Eastern Creek Business Hub (SSD 5175 Mod 4 and SSD 8588 MOD 2)  
**Request for Additional Information**

I refer to the assessment of SSD 5175 MOD 4 (new roundabout and stormwater changes) and SSD 8588 MOD 2 (Lot 2 layout changes).

drawing title
STAGE 1 PROPOSED PLAN

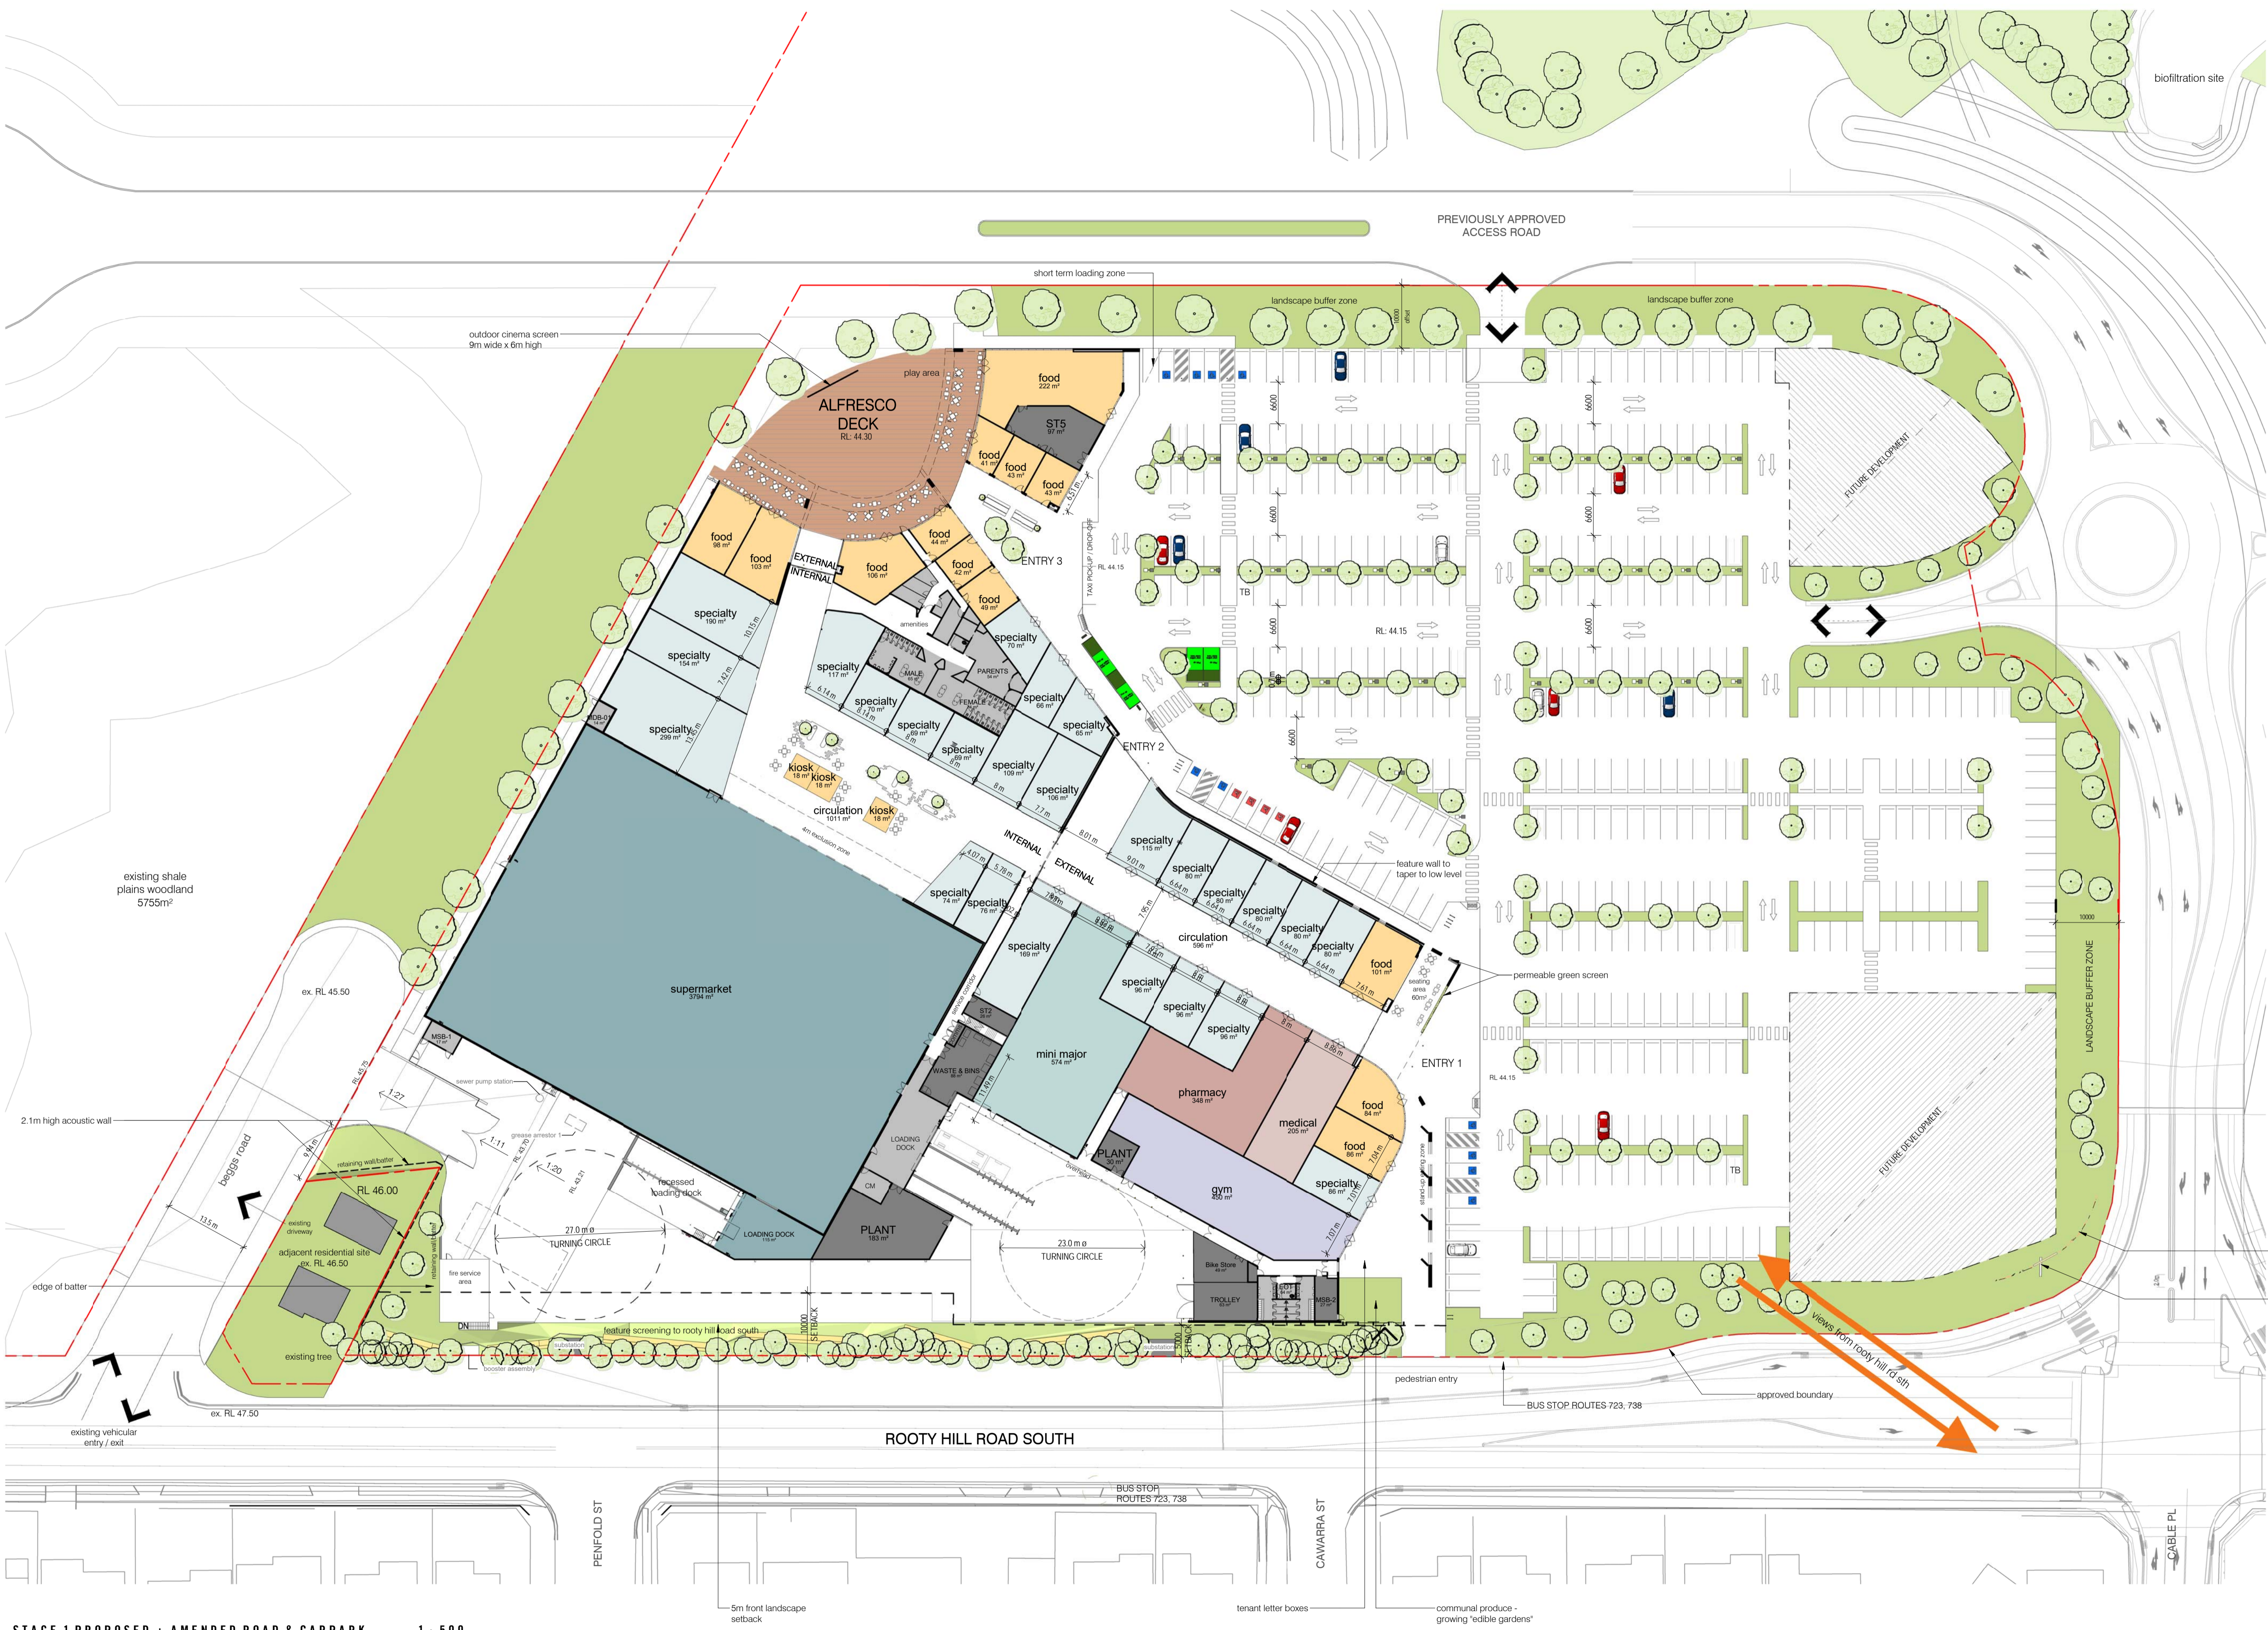
The Department has received a response from Roads and Maritime Services (RMS) in response to the additional information provided (attached). RMS note the proposed roundabout may impact on the functioning of the Rooty Hill Road South / Cable Place intersection. To address this, RMS request access to Lot 2 from the proposed roundabout be modified from an entry/ exit access to an exit only access arrangement.

The Department requests amended concept plans (SSD 5175) and amended detail design plans (SSD 8588) be submitted reflecting the above. This should also be accompanied by an updated traffic statement addressing the suitability of the revised access arrangements into Lot 2.
